CITY OF ALBUQUERQUE

June 30, 2020

Re: B&D Industries INC
N.E Corner of Altez & Bell
Request for Certificate of Occupancy
Transportation Development Final Inspection
Engineer's/Architect's Stamp dated 7-26-19 (L20D071)
Certification dated 6-24-20

### E2 STRIPING DETAIL

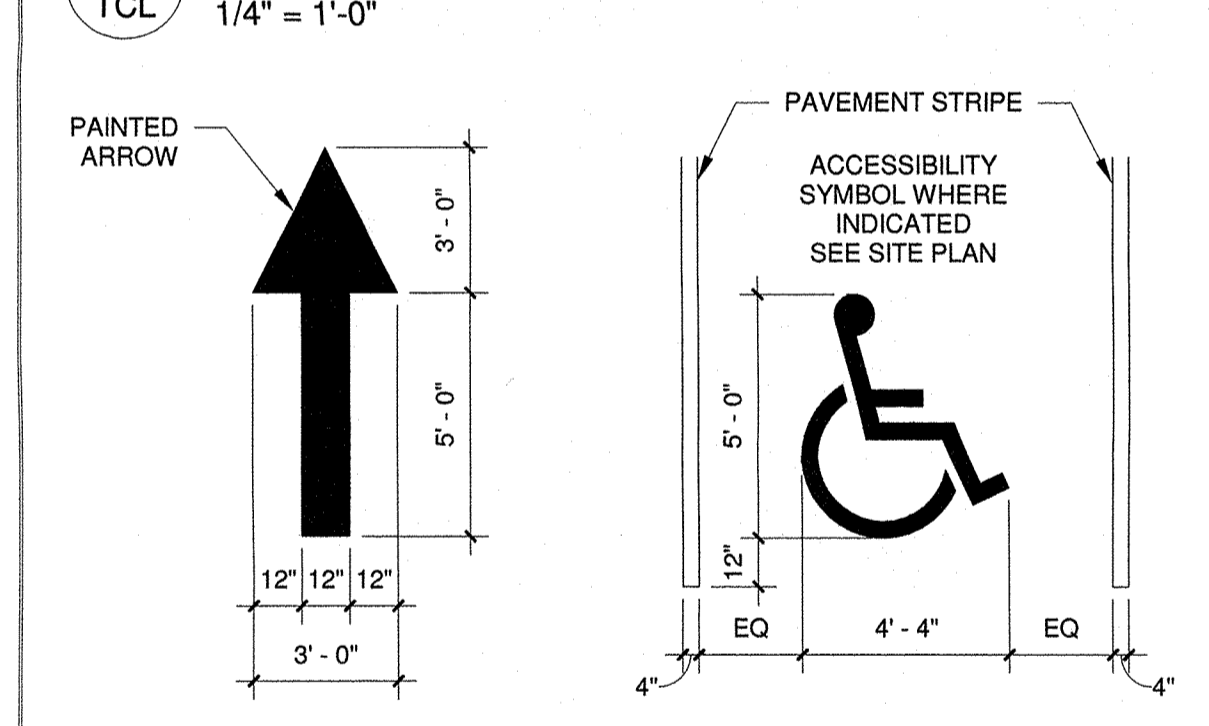
- Please correct "No Parking" in the access aisle.

- The ADA access aisles shall have the words **"NO PARKING"** in capital letters, each of which shall be at least one foot high and at least two inches wide, placed at the rear of the parking space so as to be close to where an adjacent vehicle's rear tire would be placed. (66-1-4.1.B NMSA 1978)

### E1 ADA SIGNPOST DETAIL

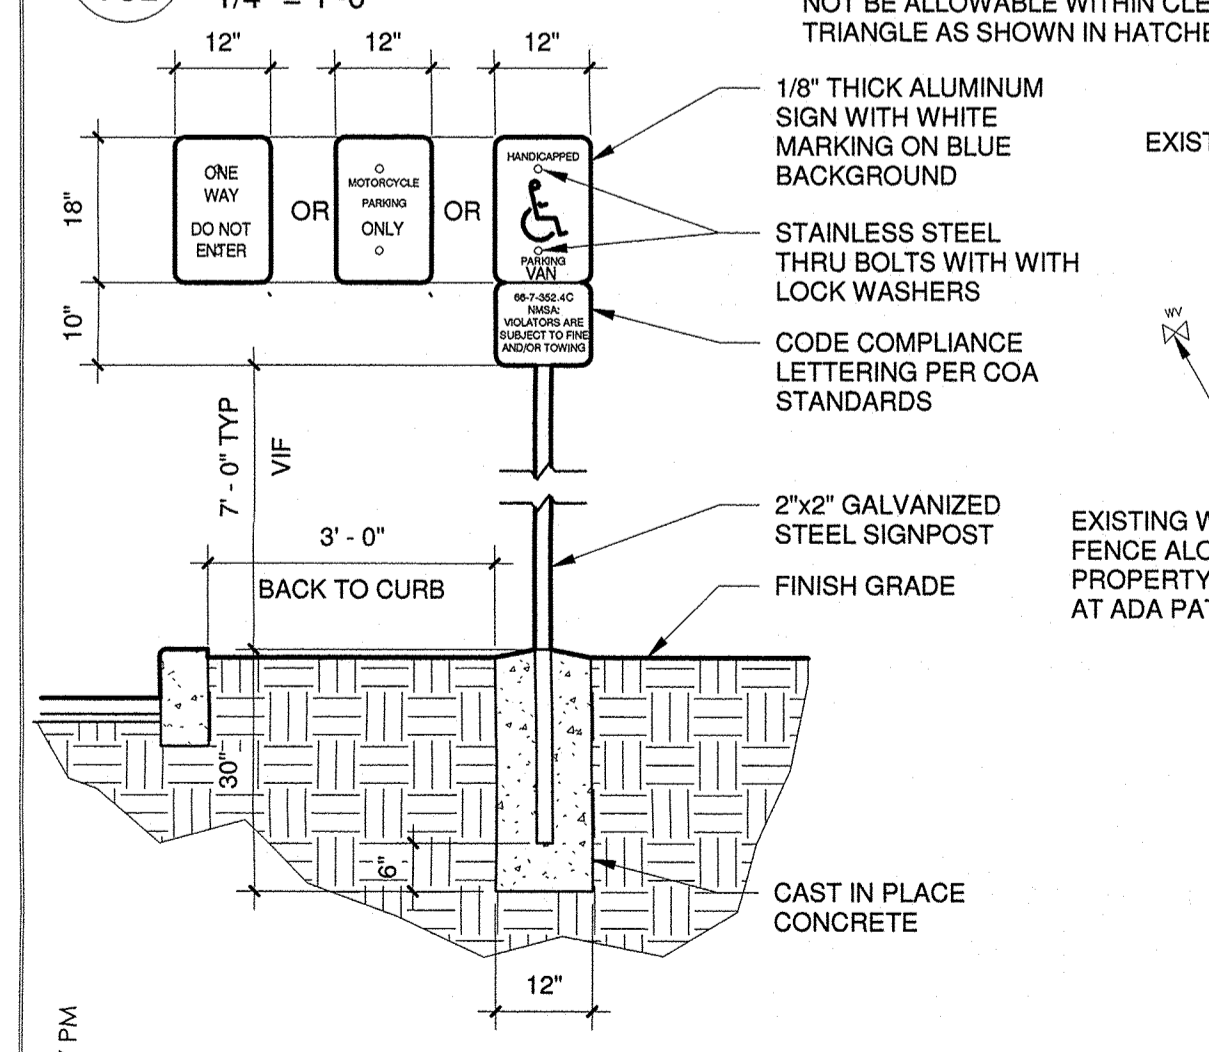
- Please correct ADA signs. The ADA accessible parking sign must have the required language per 66-7-352.4C NMSA 1978 **"Violators Are Subject to a Fine and/or Towing."**

### A1 SITE PLAN

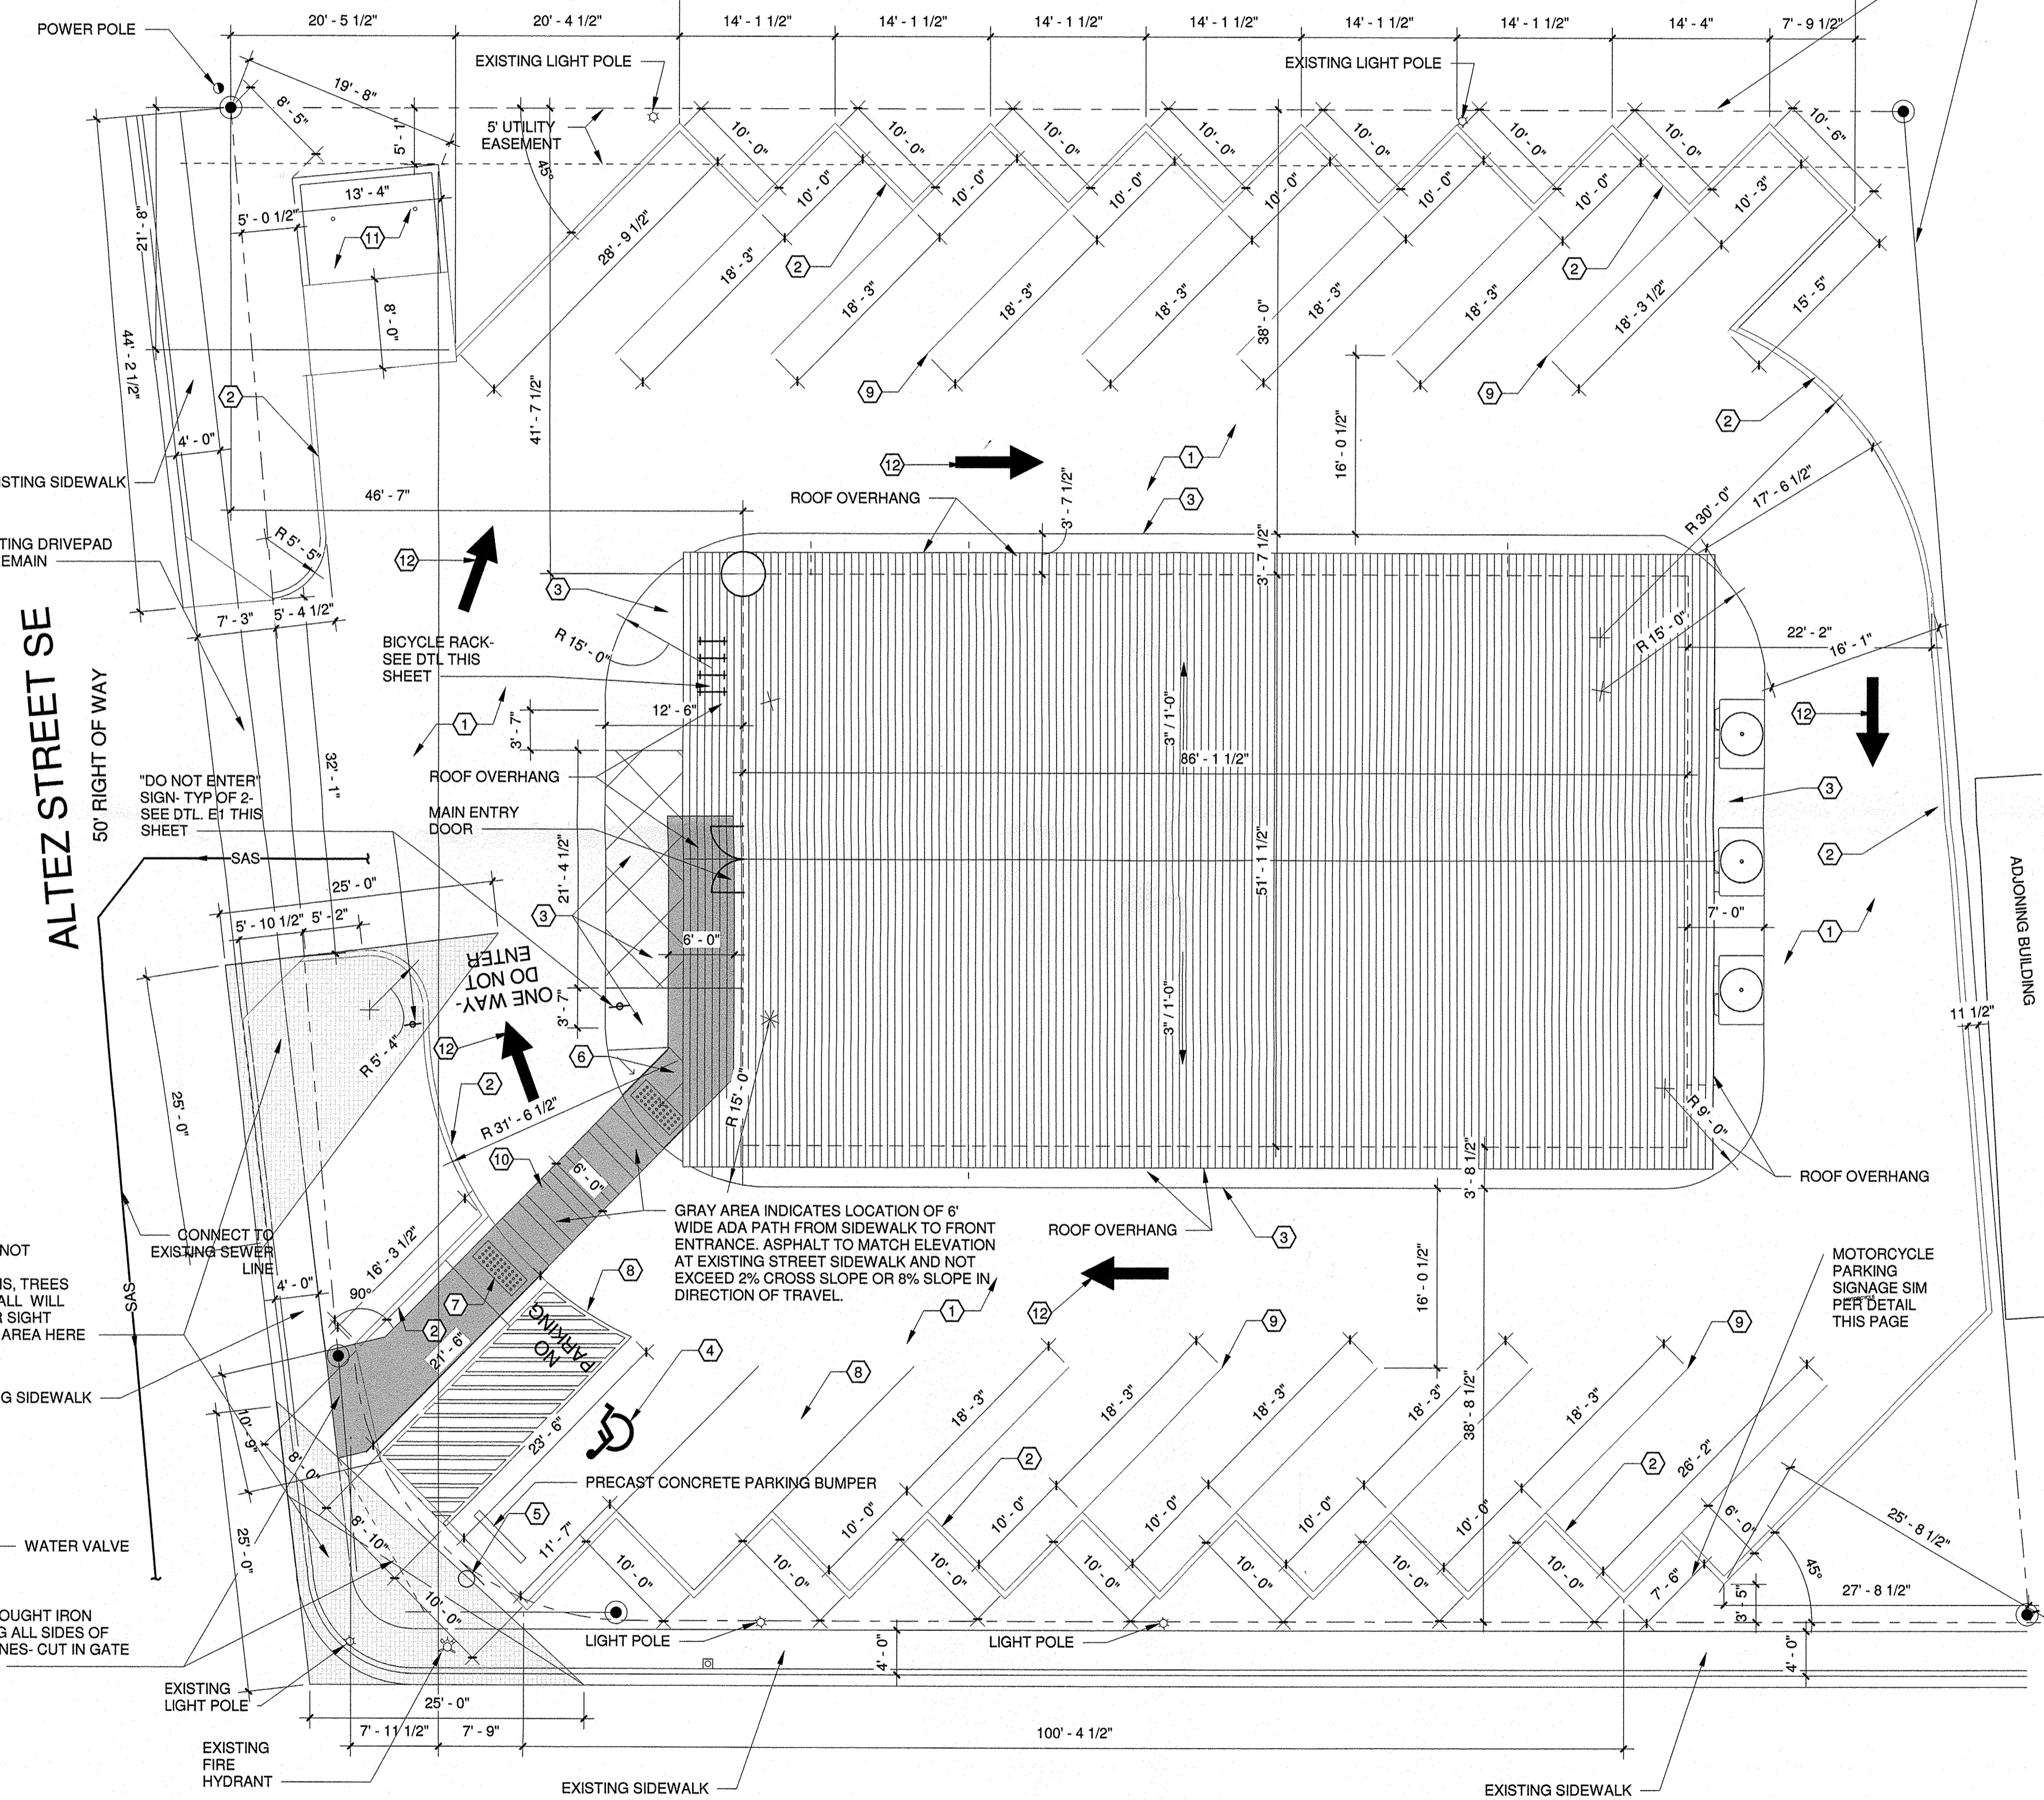
- Please add Motorcycle signs.

- Please add Bike Rack.
